Arun District Council  
Arun Civic Centre  
Maltravers Road  
Littlehampton  
West Sussex BN17 5LF  
Planning & Building Control General Enquiries  
Tel: (01903) 737756 Fax: (01903) 730442  
Dx: 57406 Littlehampton  
Minicom: 01903 732765  
e-mail: [planning@arun.gov.uk](mailto:planning@arun.gov.uk)  
website: [www.arun.gov.uk/planning](http://www.arun.gov.uk/planning)

Application No: FG/46/21/PL  
Site Address: Land between 11a The Grove and 30 Brook Lane Ferring  
Description of works: Development of 1 no. 2 bed house set over 2 floors, with first floor being partially contained within roof, along with associated parking & amenity spaces. This site is within CIL Zone 4 and is CIL liable as new dwelling.

Thank you for your internet representation made on 24th April 2021 which has been recorded as an objection with the comments as follows:

Drawing Title 028_07 Proposed West & South Elevations Land between 11A The Grove and 30 Brook Lane, Ferring	
Completion date 17/03/2021	
Drawn by Guy Rochez	
Scale: 1:100@A3	
Print Size: A3	
Notes:

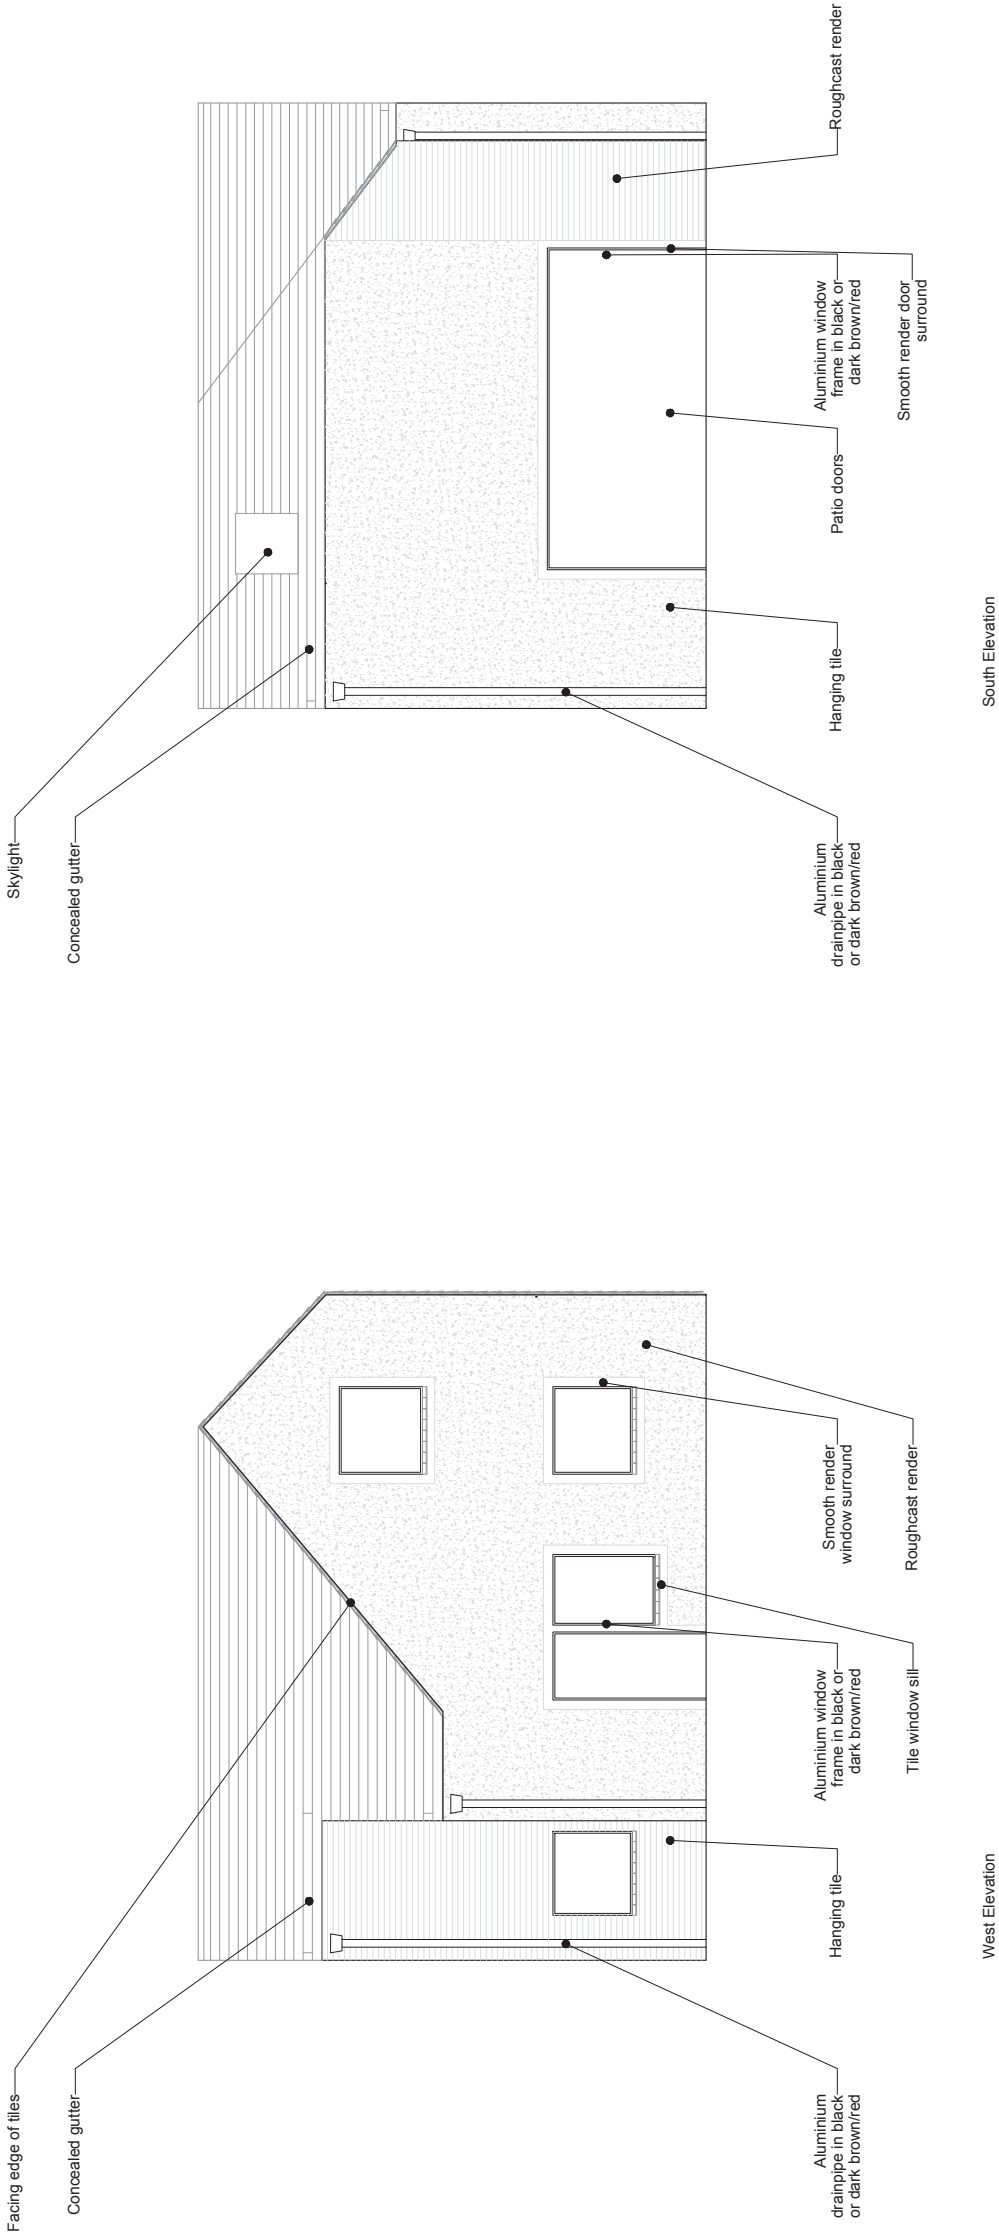
As a builder myself I know this cannot be built from within the plot. How can the rear elevation be rendered during the build or maintained in the future when its only going to be 25cms from the boundary wall. Absolute madness!

Drawing Title 028_02 Proposed Ground Floor Plan Land between 11A The Grove and 30 Brook Lane, Ferring					
Completion date 17/03/2021					
Drawn by Guy Rochez ARB					
Scale: 1:100@A3					
Print Size: A3					
Notes:

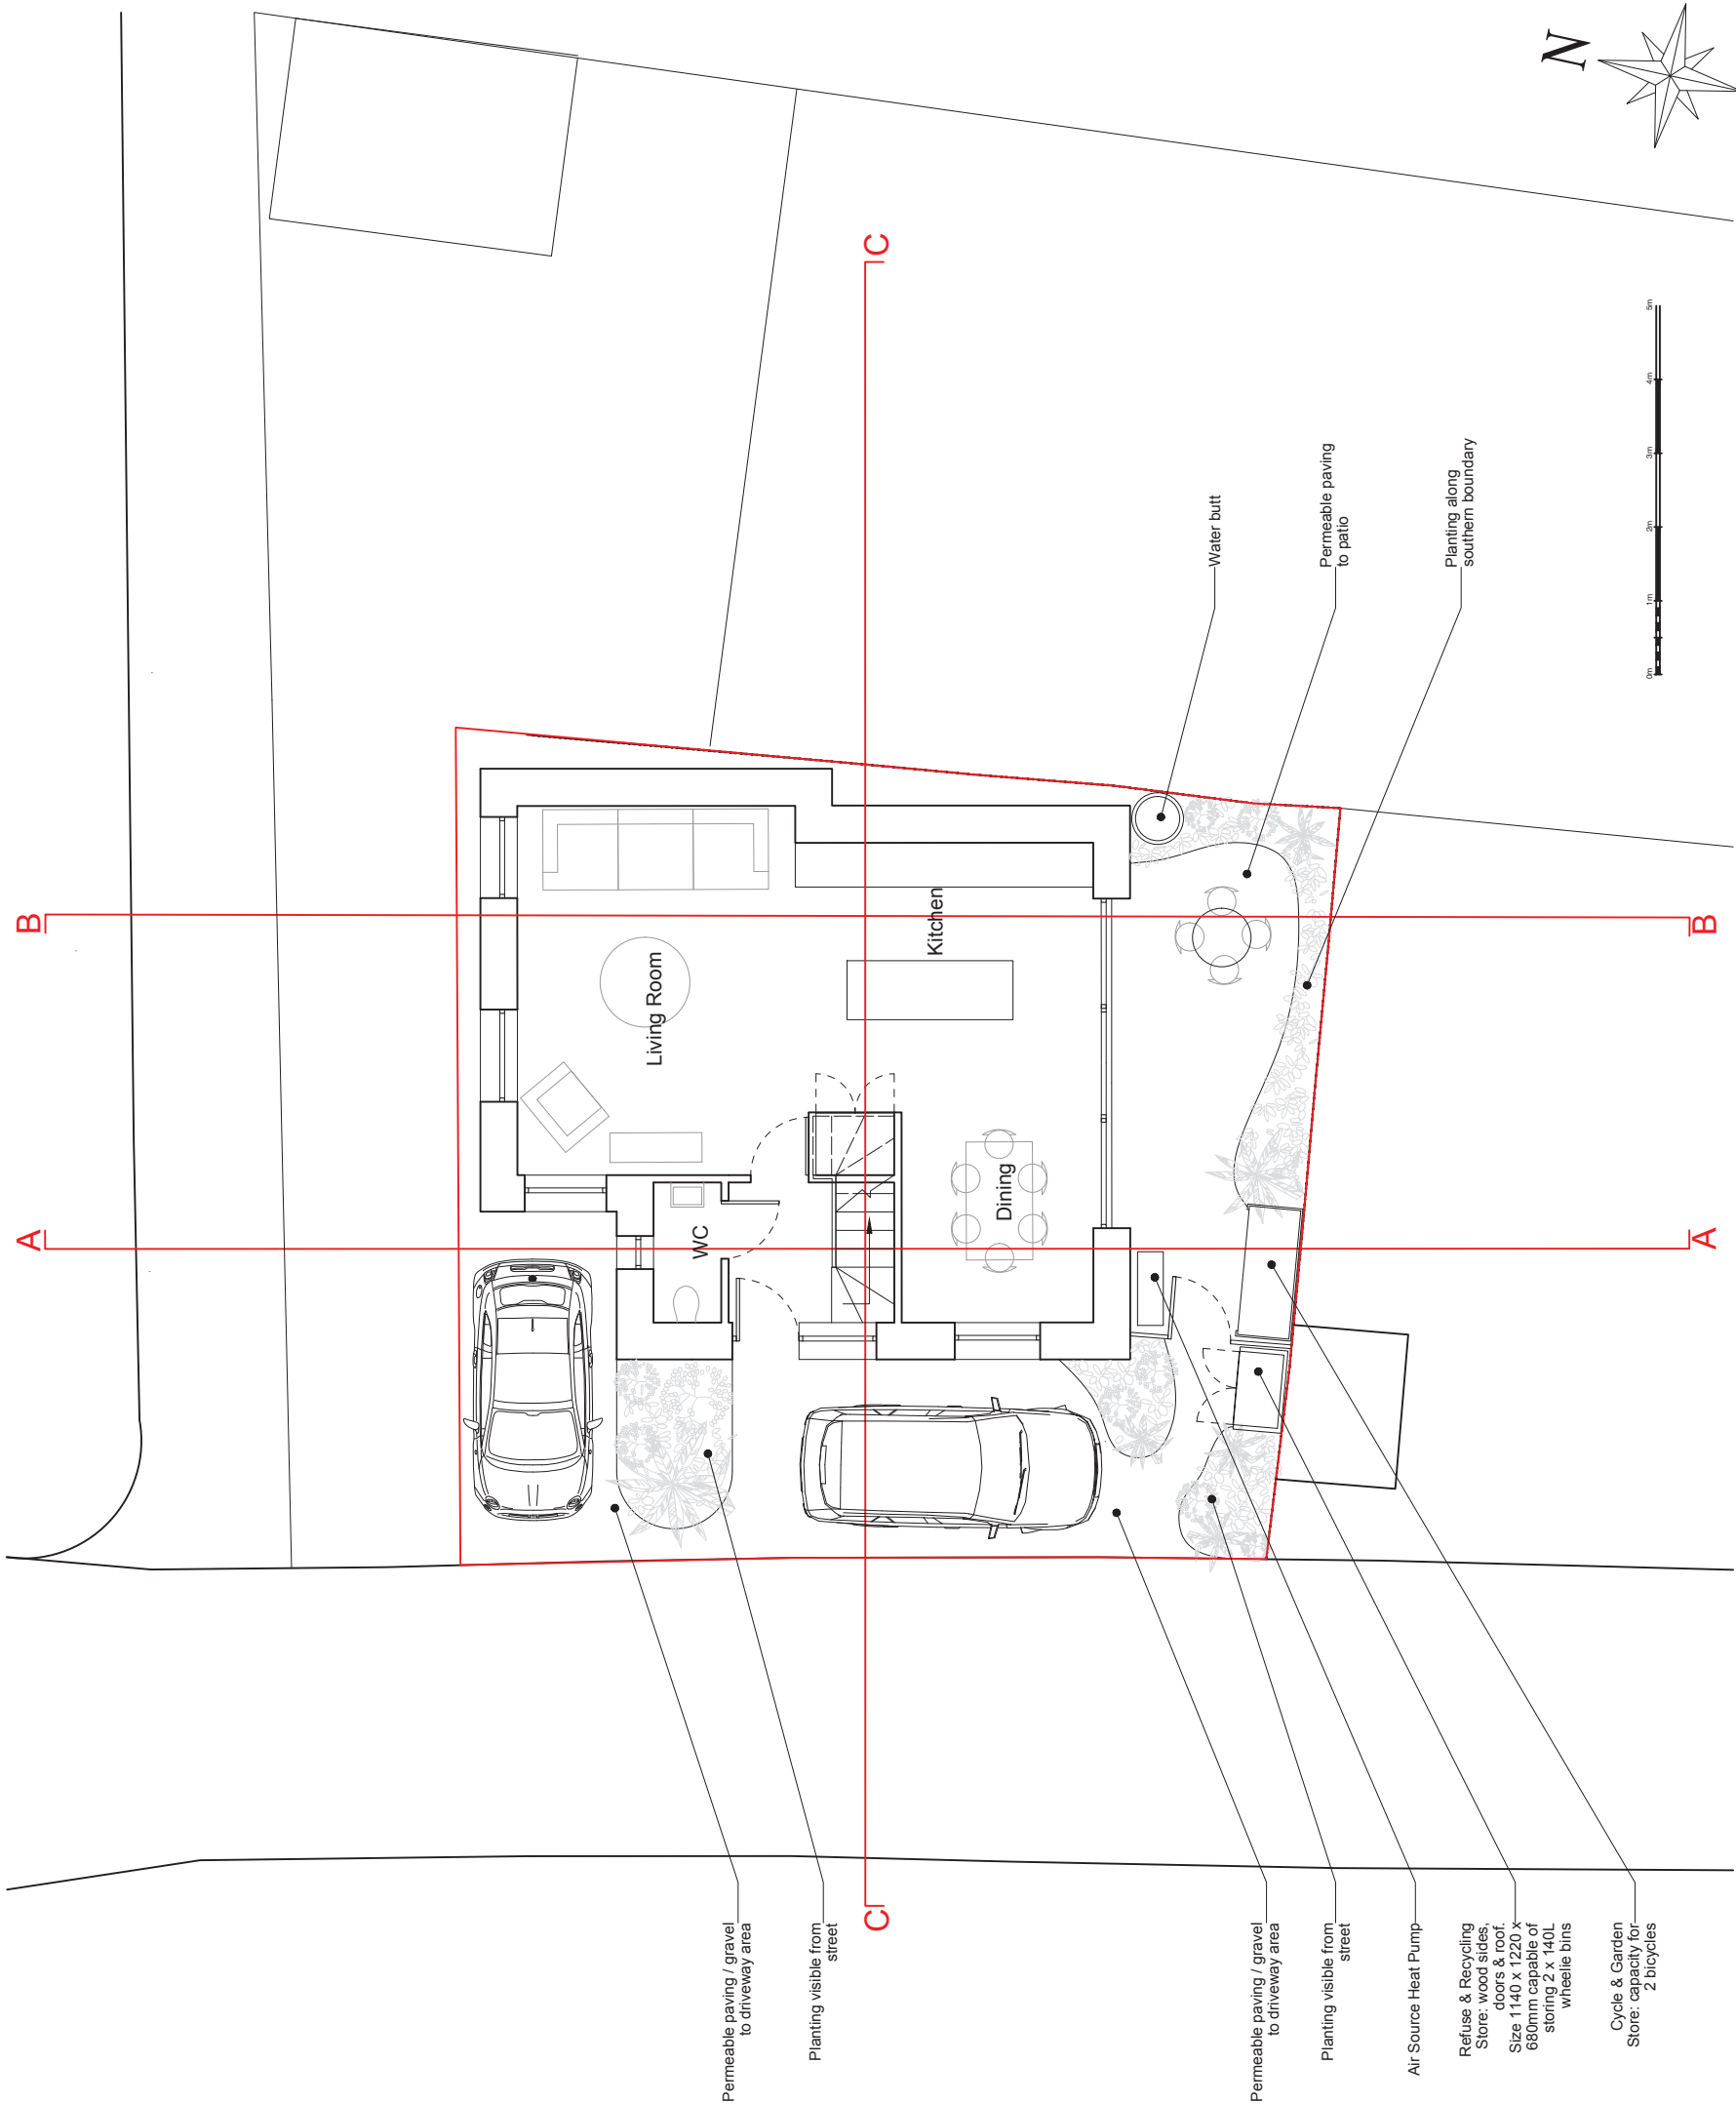
Then, I know this site quite well and cannot believe that a 2 bedroom house is proposed. This is a gross over development of the site. It will over look and overshadow the neighbouring properties. It will add to parking problems and has an outside space completely impractical for a 2 bedroom property.
